Boston Alternative Energy Facility

Appendix B5 to Natural England's Deadline 8 Submission

**Natural England's Comments on Without Prejudice Habitats Regulations Assessment
Derogation Case: Compensation Measures [REP6-026]**

15th March 2022

**Figure 1-1 Cargo vessel numbers arriving at the Port of Boston between 1994 and 2020**

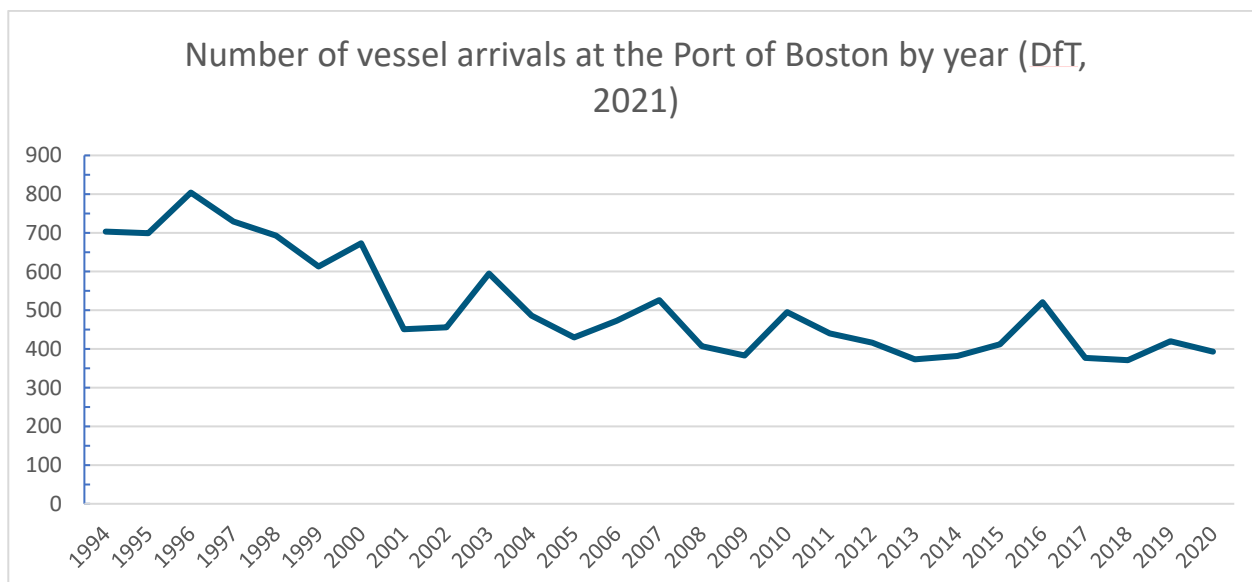
3.	1.1.16	Please see NE Appendix F5 for comments on compensation measures and draft DCO.	
4.	Figure 1-1	We note that the addition of 580 vessels per year to current numbers would increase vessel movements to greater levels than any since 1994 at least.

Figure 3-1 Possible Locations of compensation options

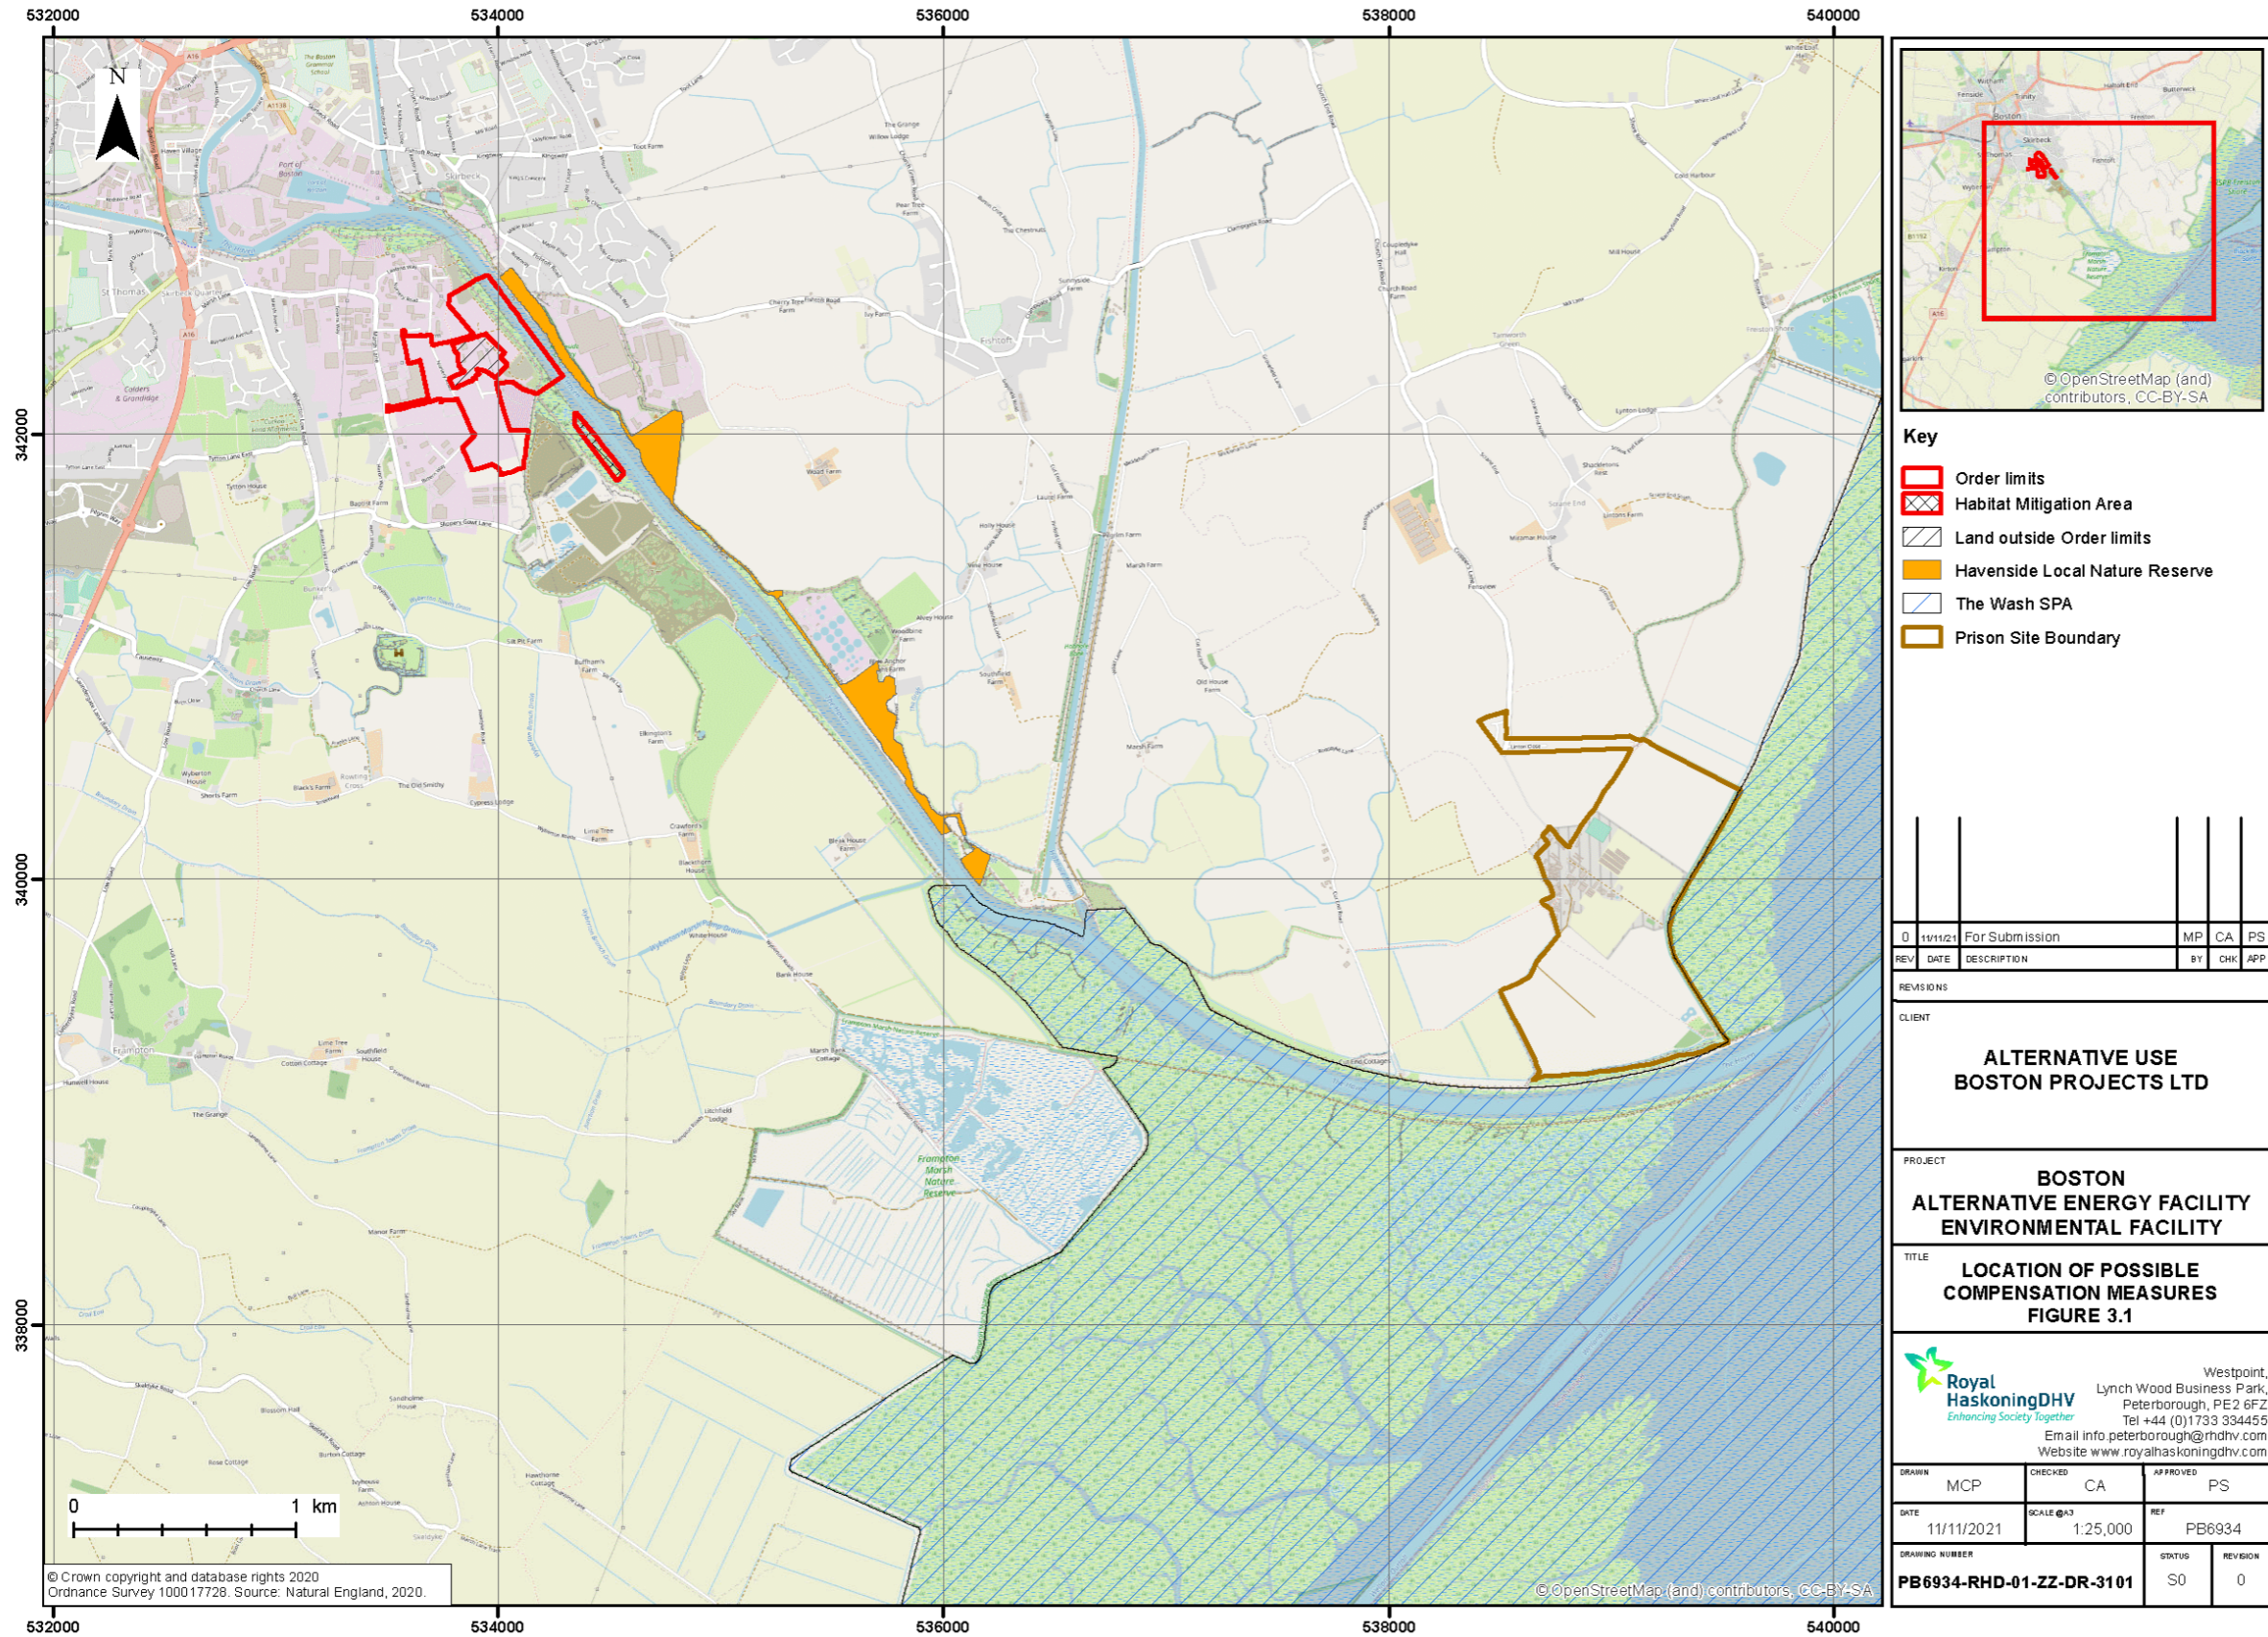
26.	Figure 3.1	NE presume the locations of the two arable fields being put forward is not yet common knowledge and this information will be shared?	
27.	4.6.3 and 4.6.4	Natural England queries over what timeframe is this being secured? I.e. as a minimum for the duration of the life-time of the site occupation (and decommissioning phase)? What about the wharf? If that is left in-situ as currently expected? This land (as long as it is used by SPA/ Ramsar bird species) should be considered Functional Linked Land and should be included within the SPA network to retain the sites network coherence. And will need to be managed as such.
